**From:** Anita Gardner  
**Sent:** 21 February 2019 18:08  
**To:** Planning.Responses  
**Subject:** FW: LU/357/18/PL - 18-22 East Street, Littlehampton, BN17 6AW

**From:** Kate Giddings  
**Sent:** 21 February 2019 17:27  
**To:** Anita Gardner  
**Cc:** Anna Appleton  
**Subject:** LU/357/18/PL - 18-22 East Street, Littlehampton, BN17 6AW

Drawing Title
Existing - Plot 22
Lower Ground, Ground &
First Floor.

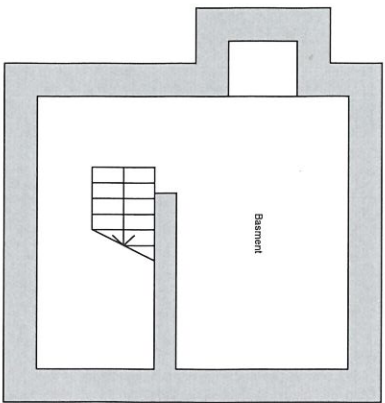
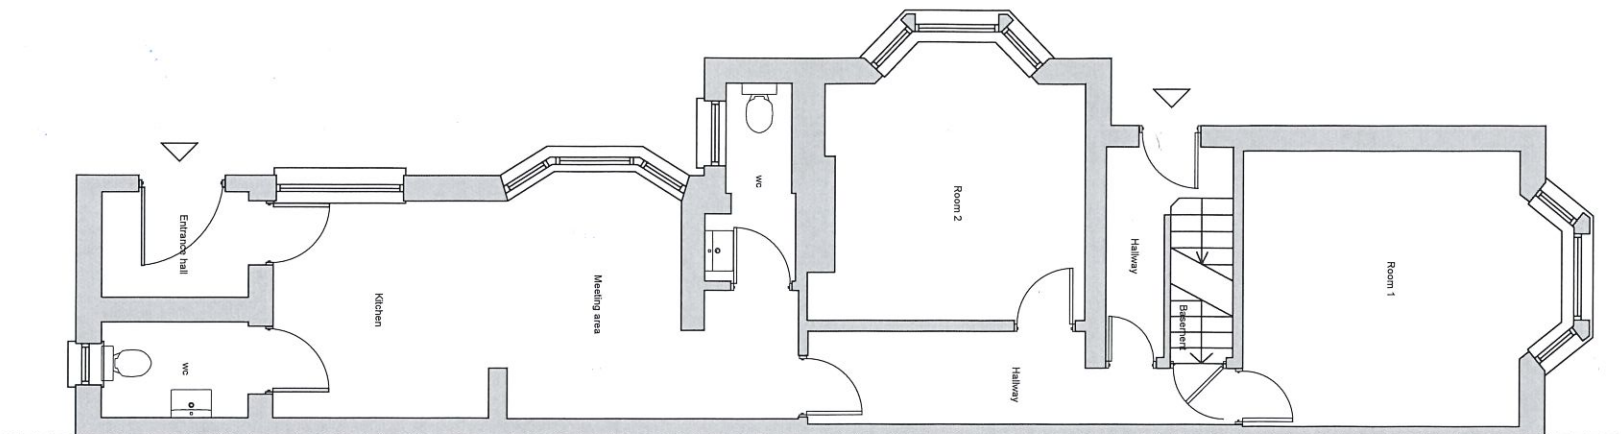
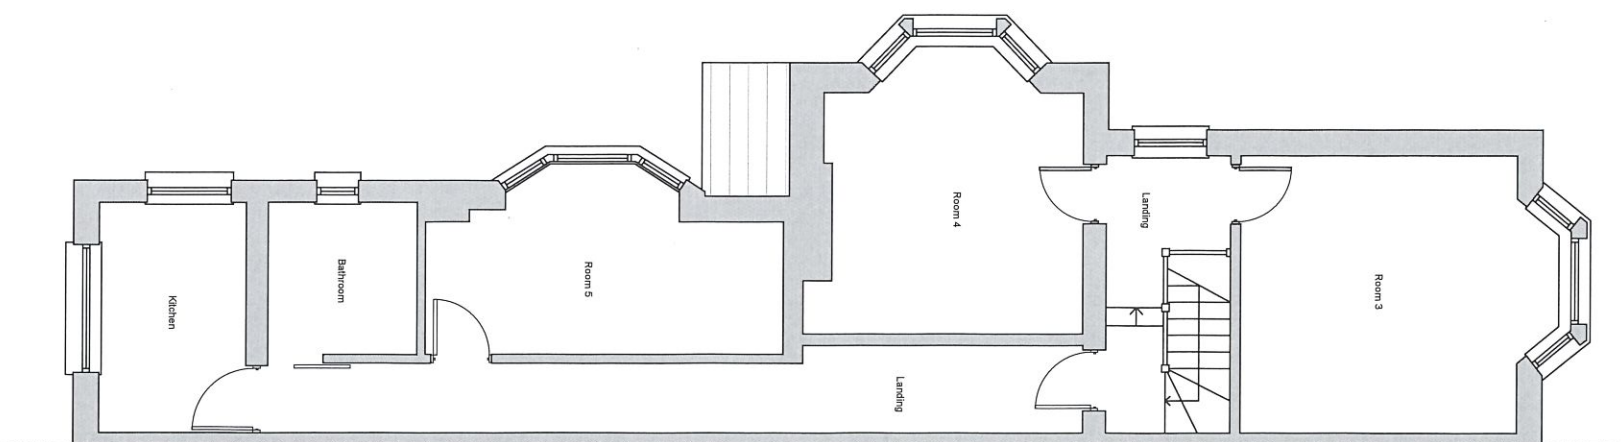
- More details is required regarding the proposed plant room occupying the lower ground floor of no. 22 East Street (including the type of plant, hours of operation, noise-reduction measures, etc.)
- Works of demolition or construction, including the use of plant and machinery, necessary for the implementation of this consent shall be limited to the following times:
  - 08.00 – 18.00 hours Monday to Friday
  - 08.00 – 13.00 hours Saturday
  - No work permitted on Sunday or Bank Holidays
